**Response to Planning application from Hertfordshire County Council (T and CP GDP Order 2015)**

District ref: 6/2015/1997/MAJ  
HCC ref: WH/284/2015  
HCC received: 23/10/2015  
Area manager: James Dale  
Case officer: Alan Story

Comet Hotel  
St Albans Road West  
Hatfield  
AL10 9RH

Extension and refurbishment of the Grade II listed hotel following demolition of poor quality additions.  
Erection of student accommodation comprising of 361 beds, landscaping and associated works

CLIENT FUSION RESIDENTIAL		
PROJECT HOTEL & STUDENT RESIDENTIAL COMET HOTEL SITE HATFIELD		
TITLE LANDSCAPE_GENERAL_ARRANGEMENT INDICATIVE_LANDSCAPE_SECTIONS_2_OF_3		
Status: PLANNING	Drawn: MM	Checked: BS
Scale: 1:50@A1	Date: 24.09.15	Approved: BS
Drawing Number: 2821_L_GA_2_02		Rev: 00

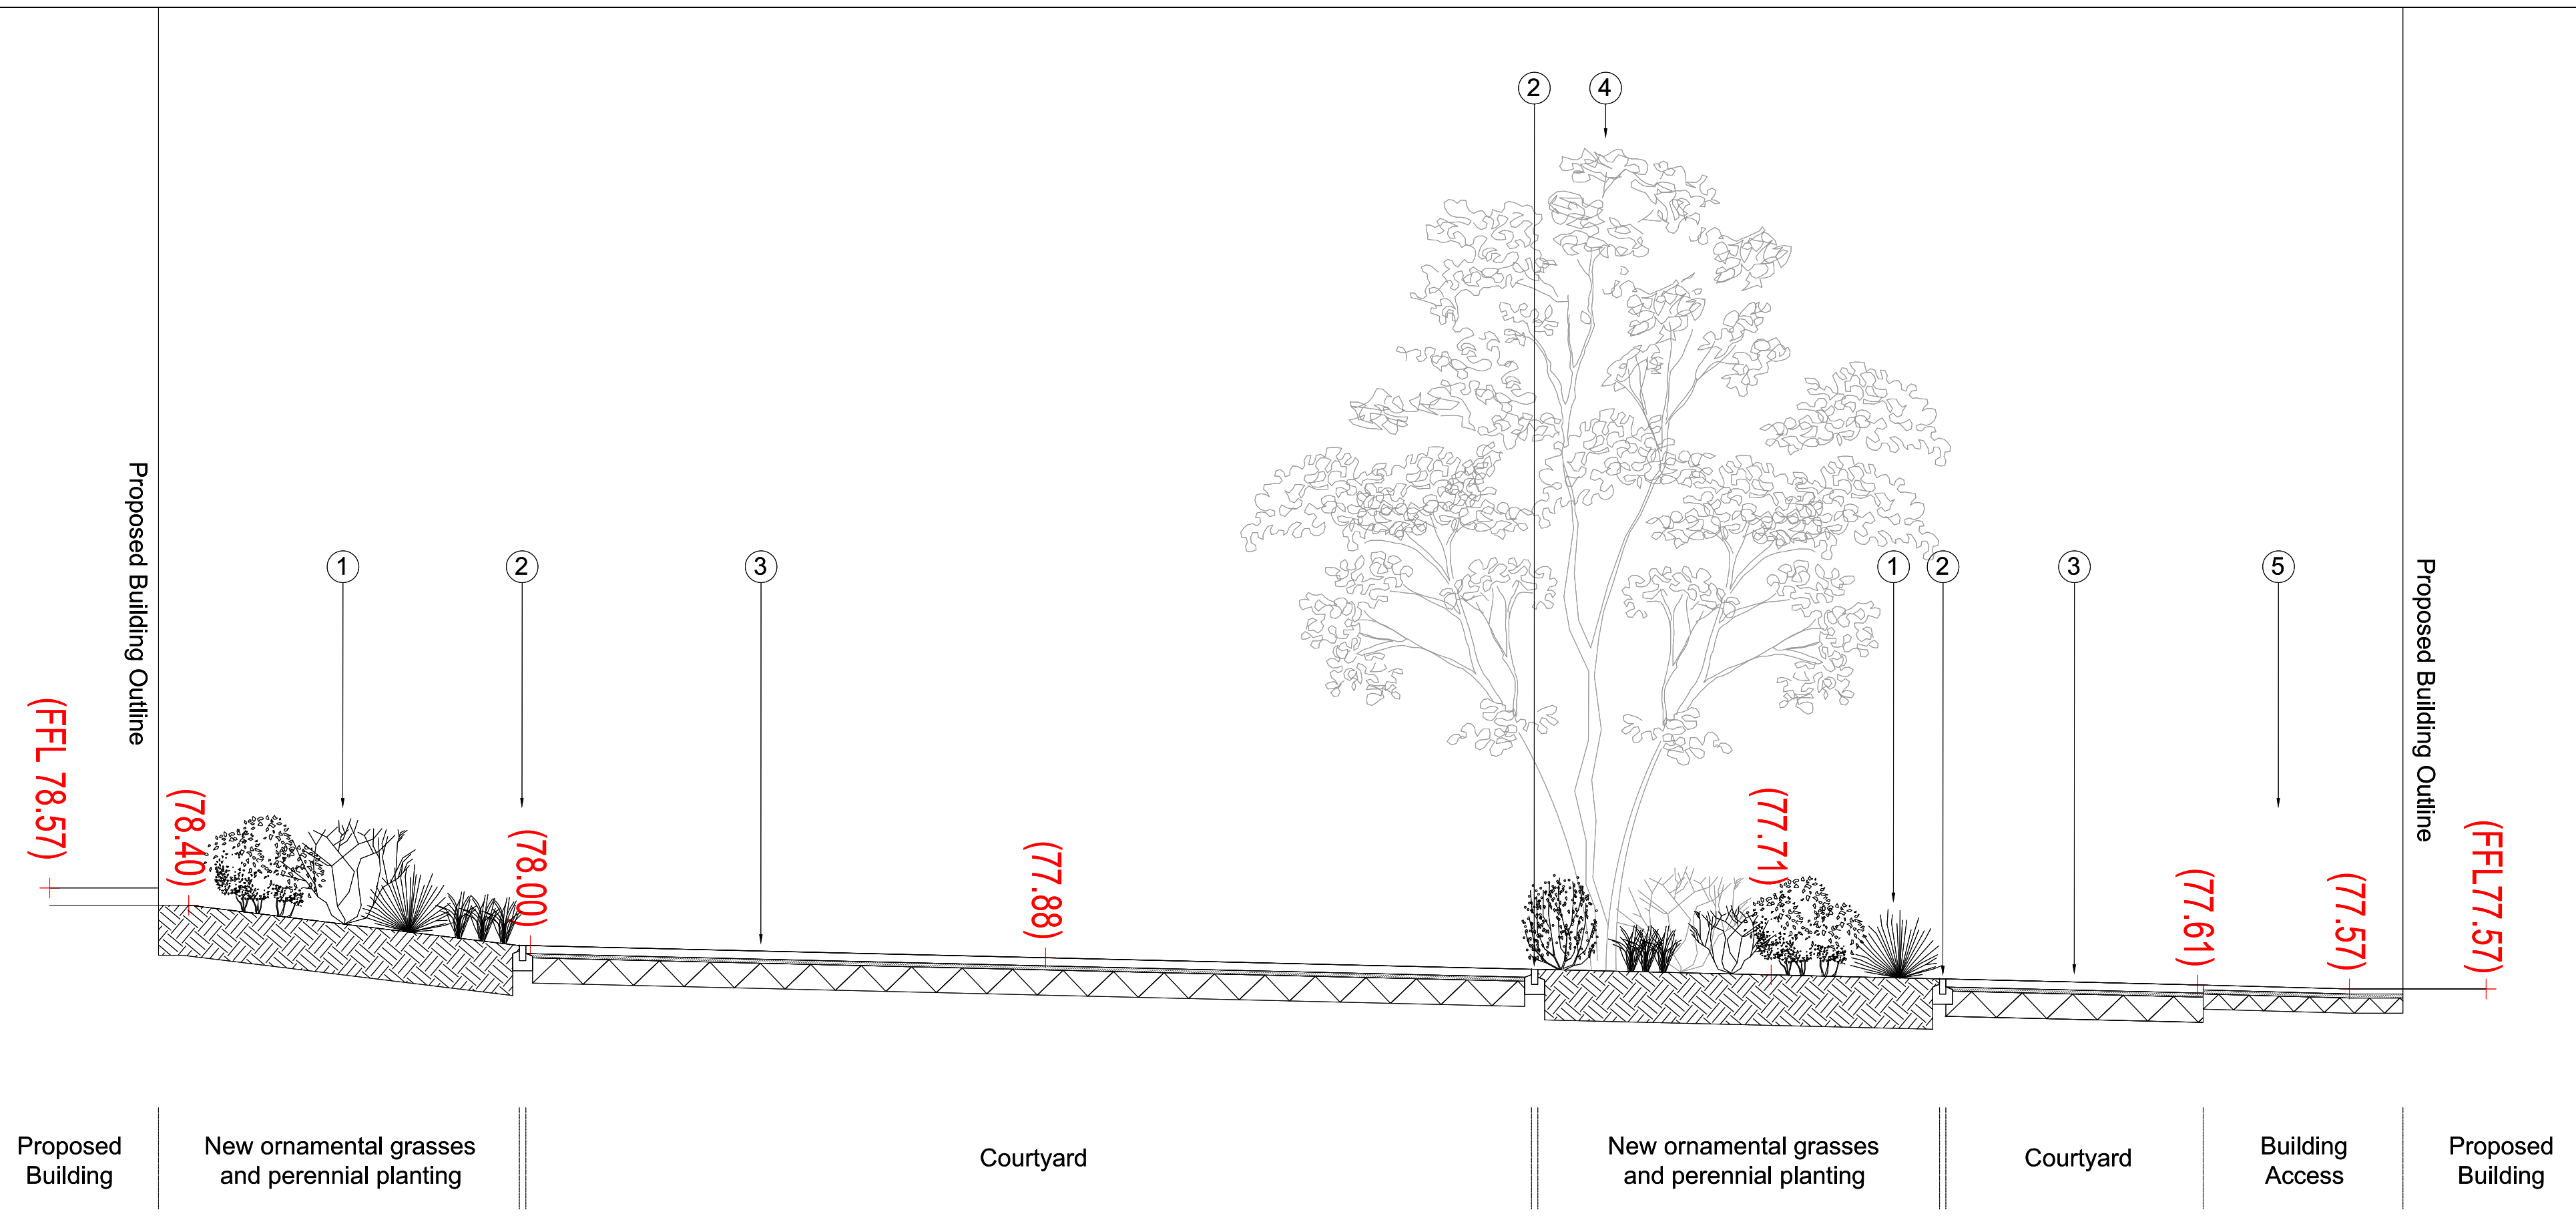
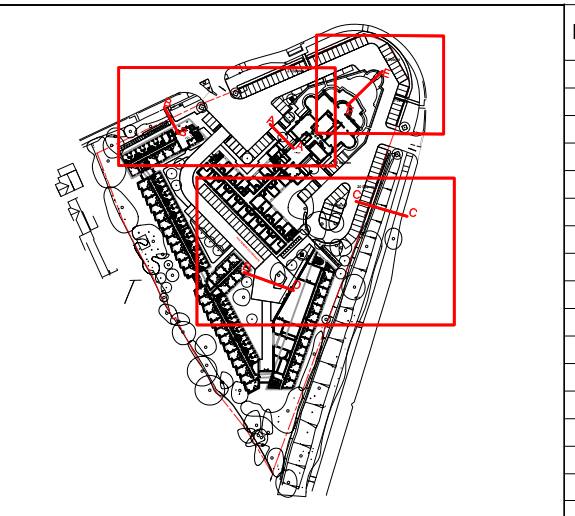
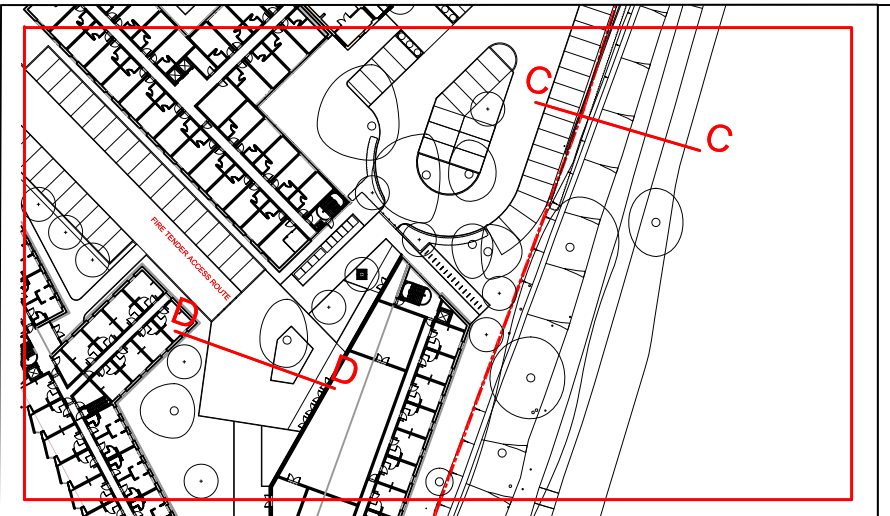
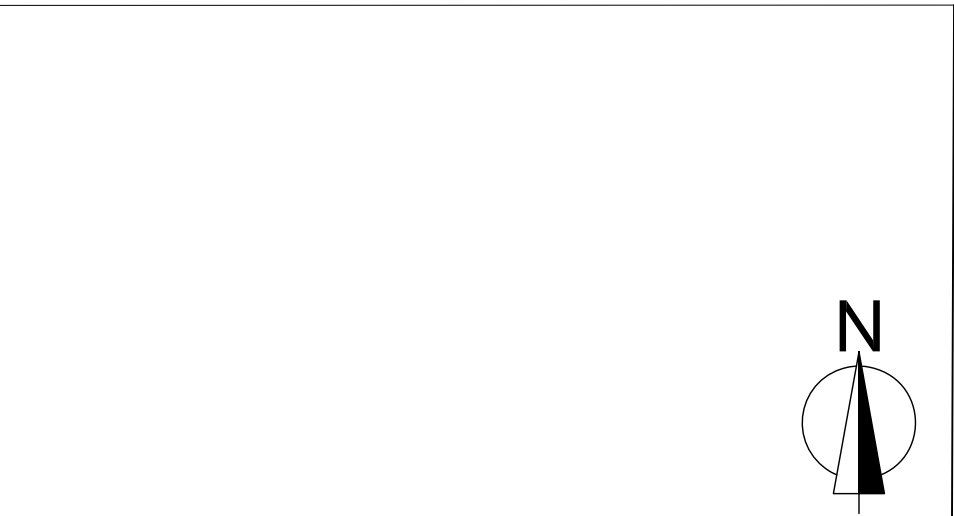
Landscaping plans (plans 2821\_L\_GA-1-01) identify that resurfacing of all hard areas include the 2 points of access, and therefore shall require a S278 relating to any works on the public highway.

The landscaping plans appear to demonstrate that existing visibility splays at each of the accesses remains uninterferred with.
